Our reference: ECM Ref: 9696081  
Contact: Gavin Cherry  
Telephone: (02) 4732 8125

1 October 2021

**Response to Request for Advice: SSD-7348-Mod-7 Oakdale West Estate  
Modification 7 at 2 Aldington Road, Kemps Creek**

Oakdale West Estate
Landscape Master Plan - MOD7

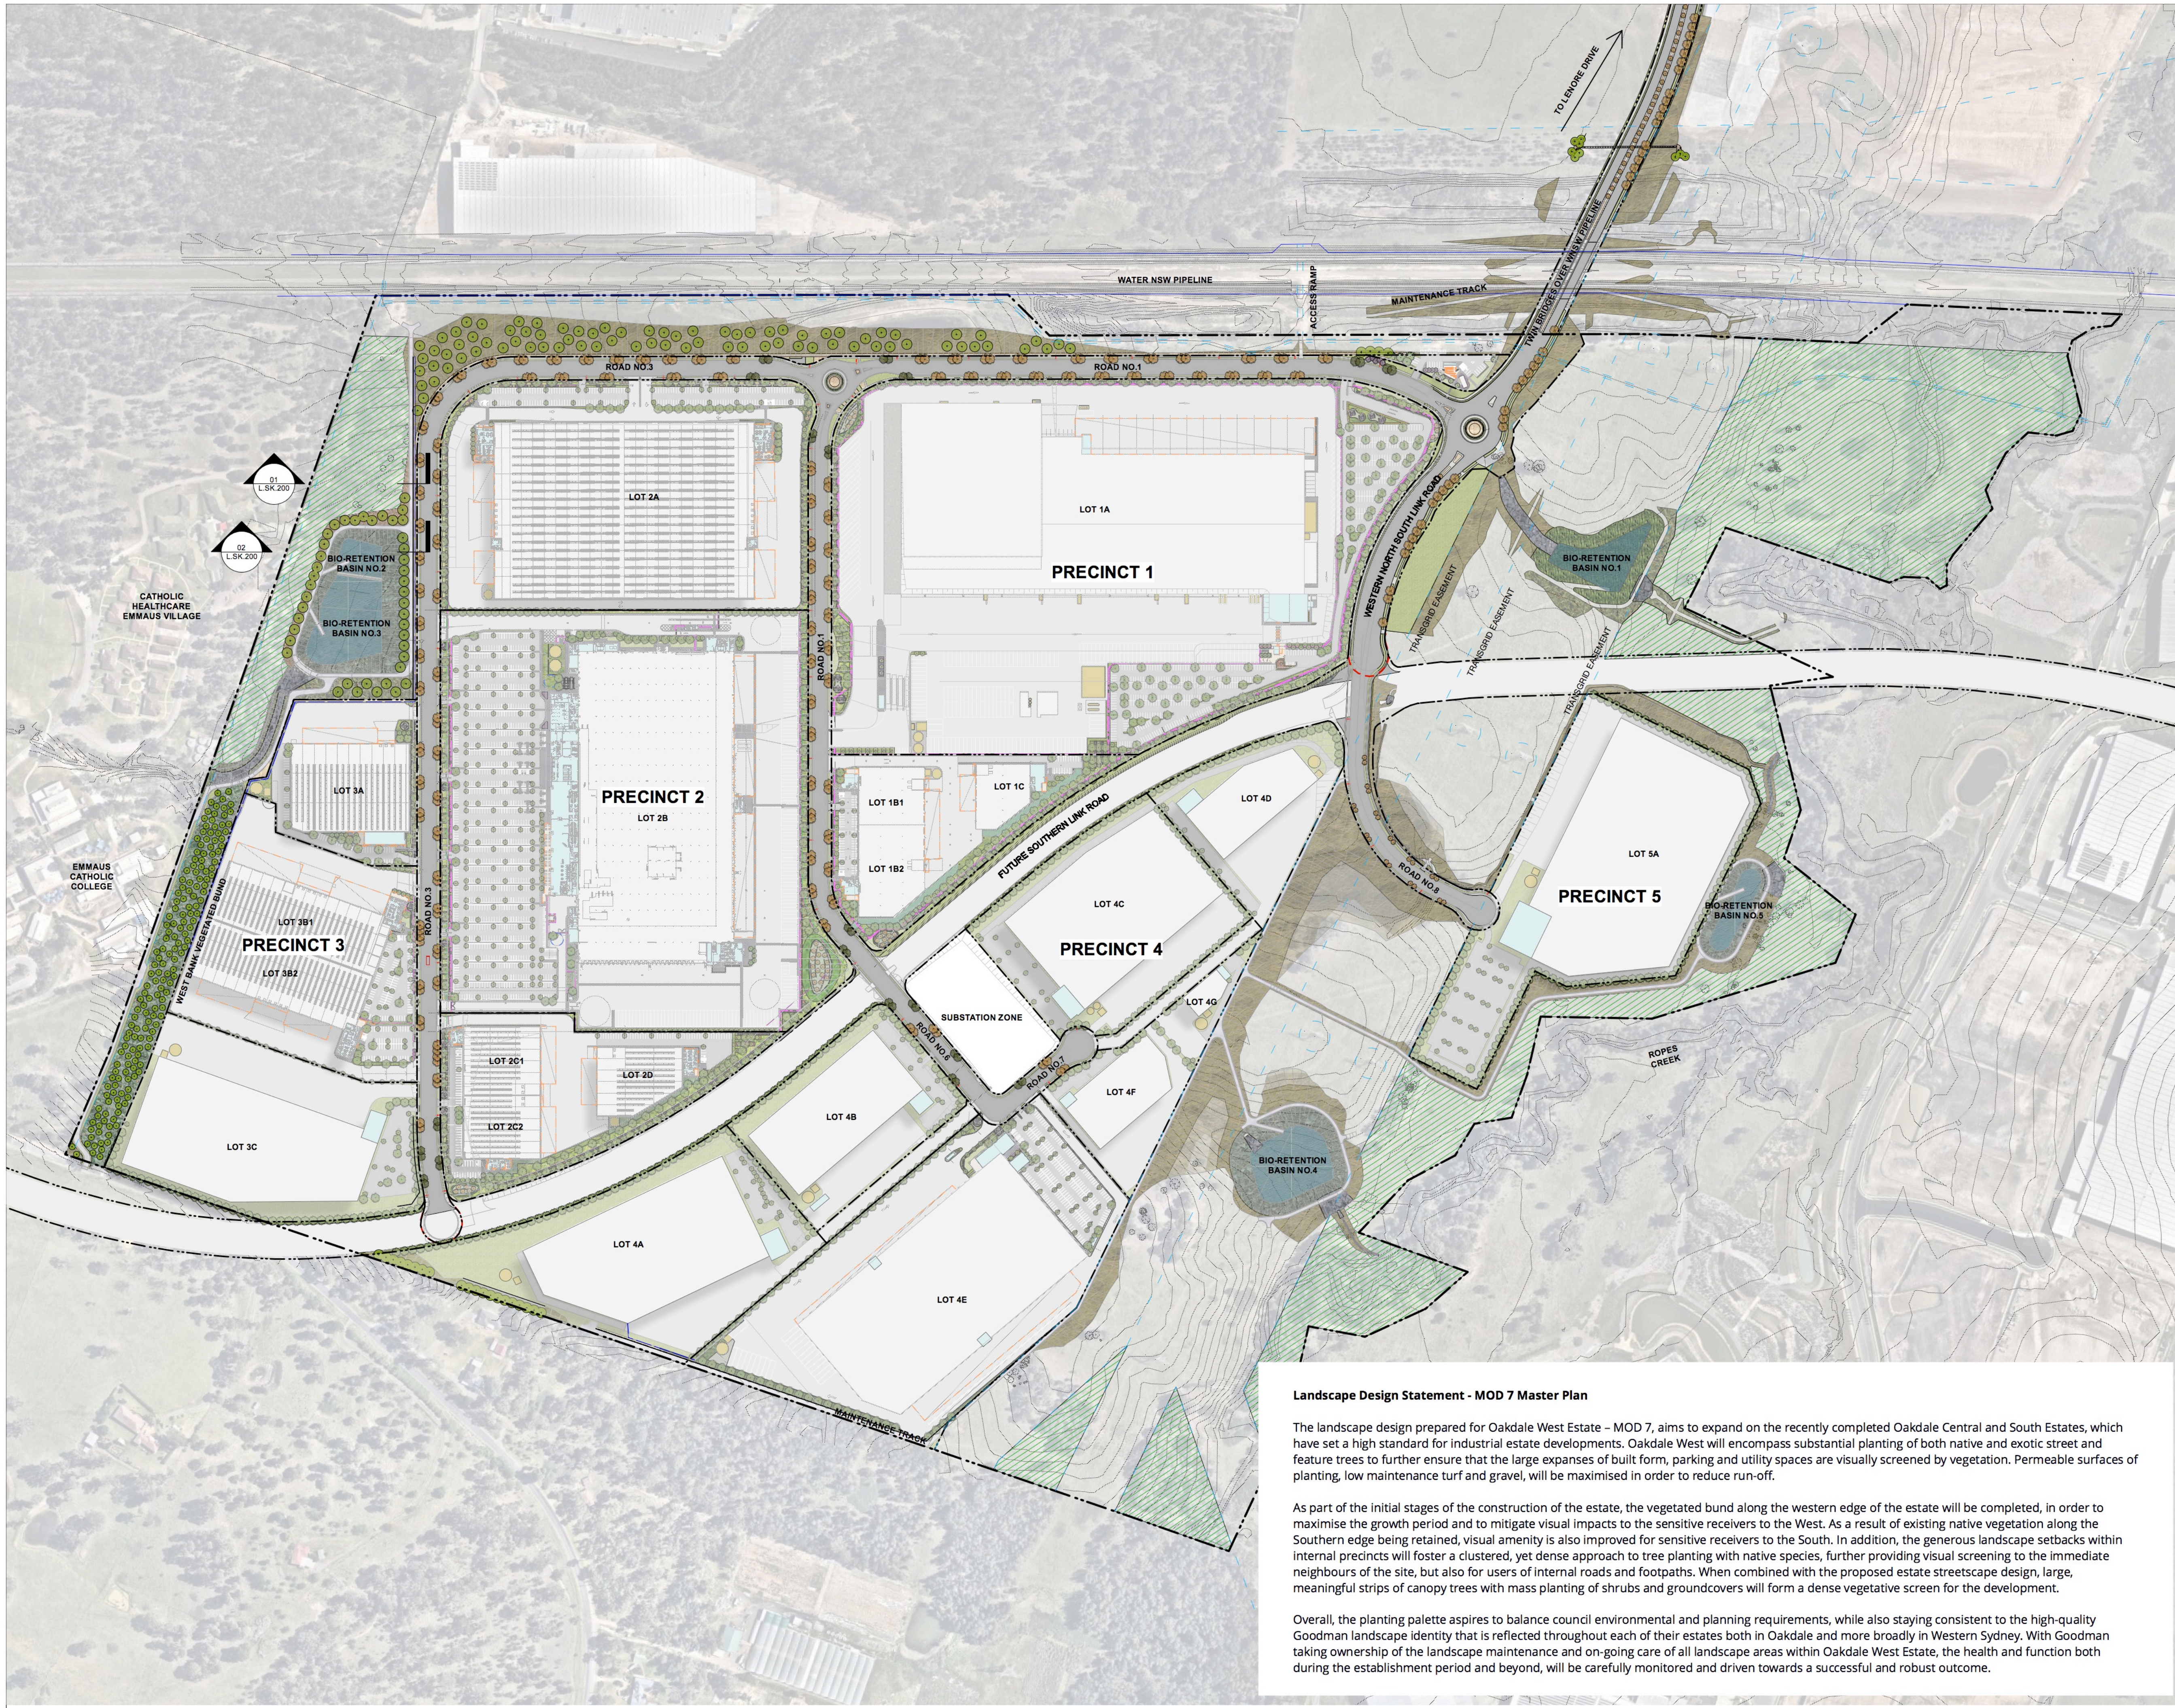
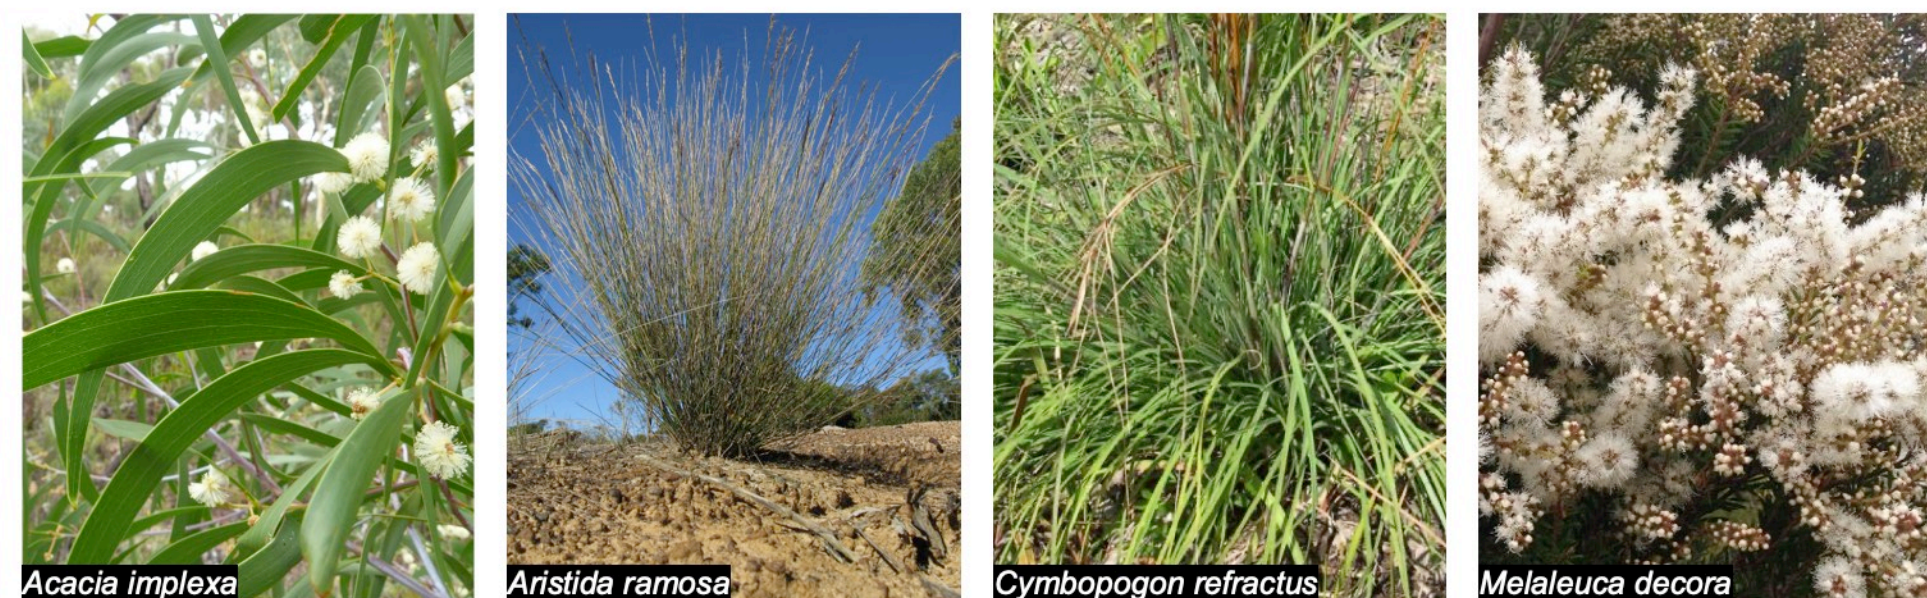
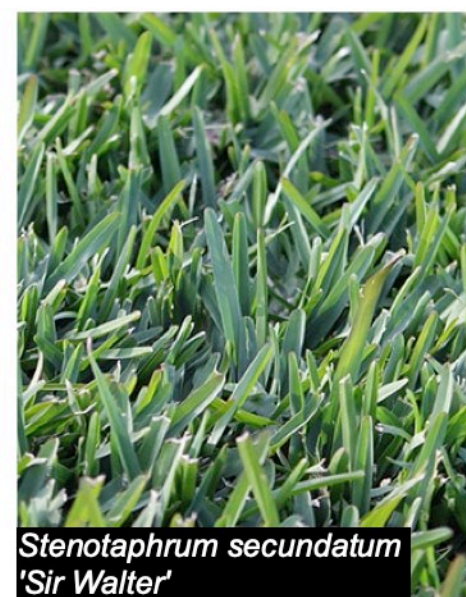
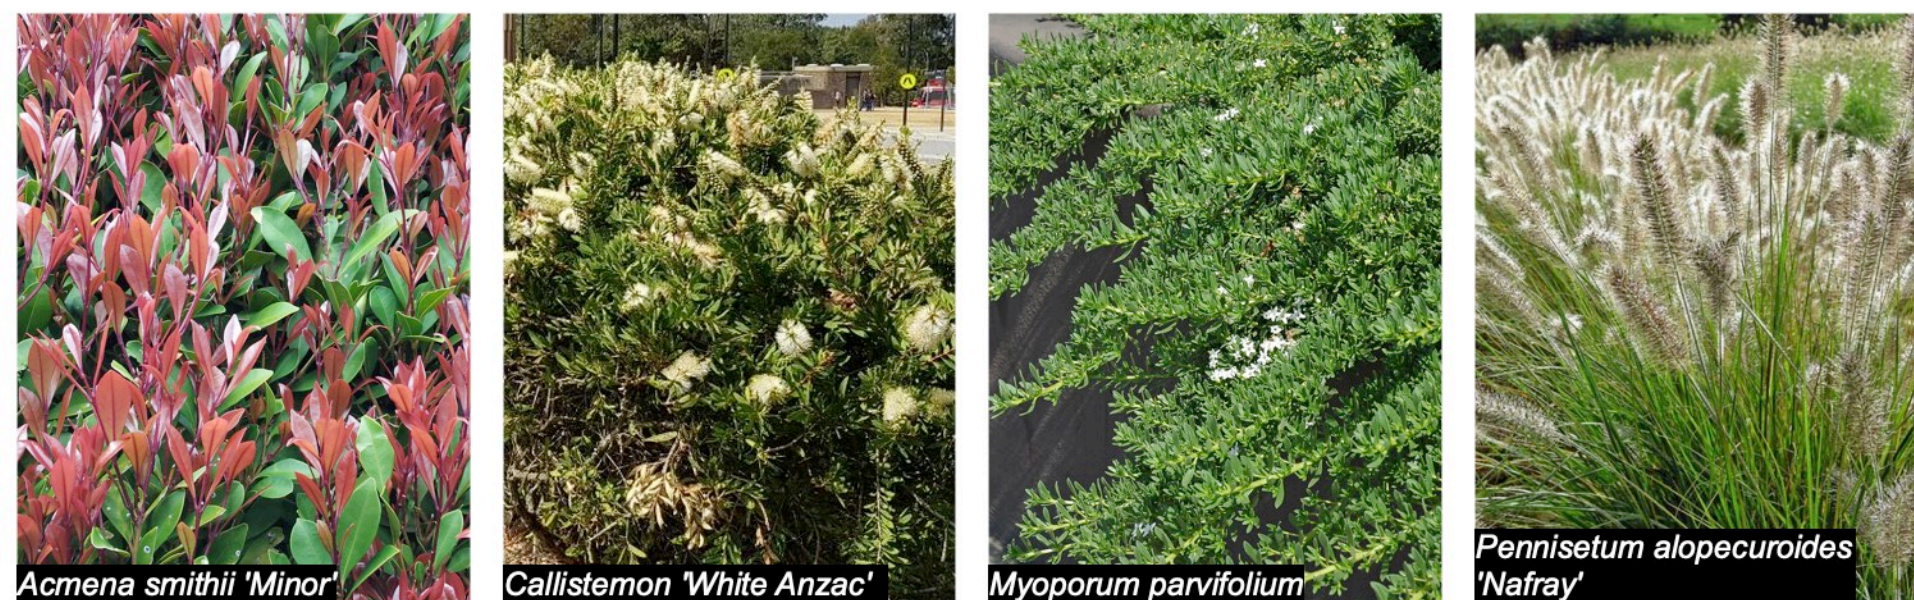
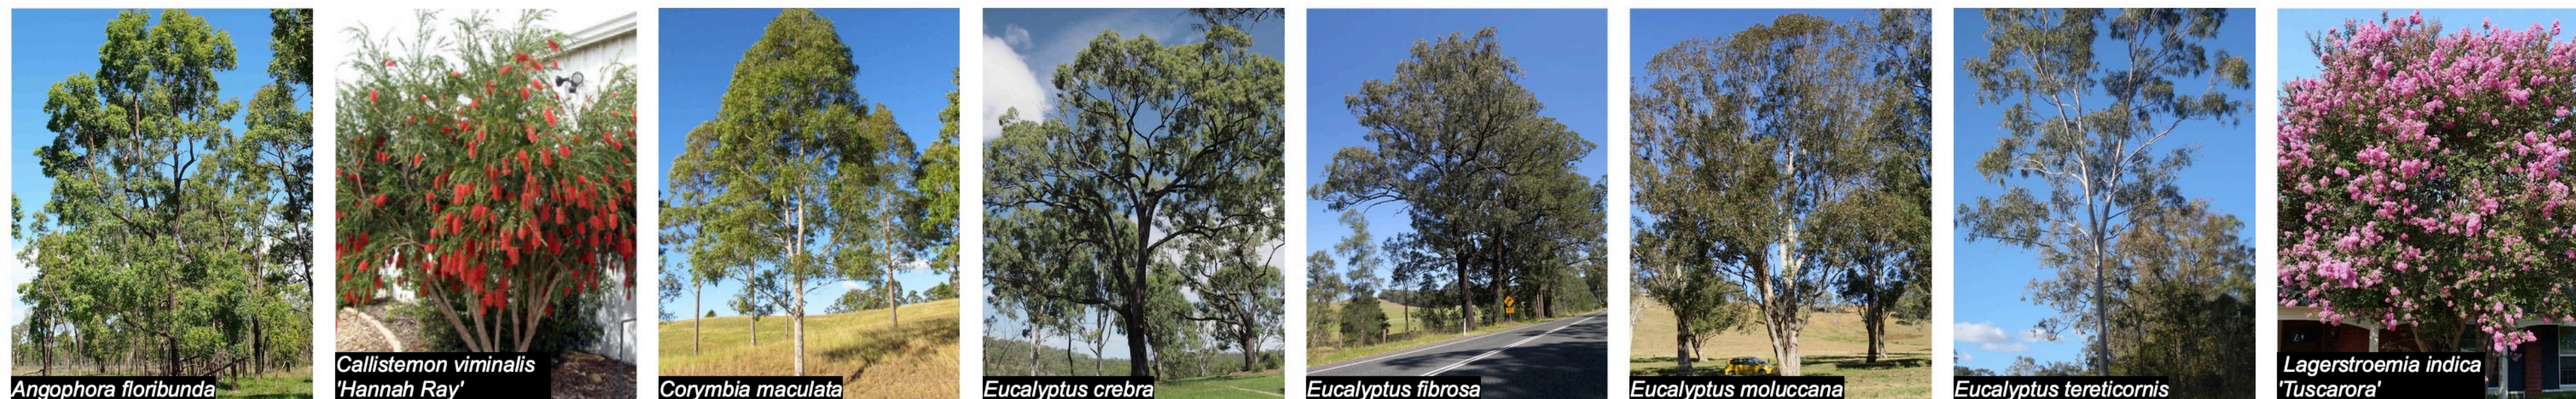
- The concerns raised and requested amendments are still considered reasonable and warranted despite the response received. In particular, the comments relating to species, shrubs, grasses and soil profiles directly relate to planting with the public domain which this modification application relates to. It is requested that the changes recommended are undertaken via revised plans or reflected within the conditions of consent.
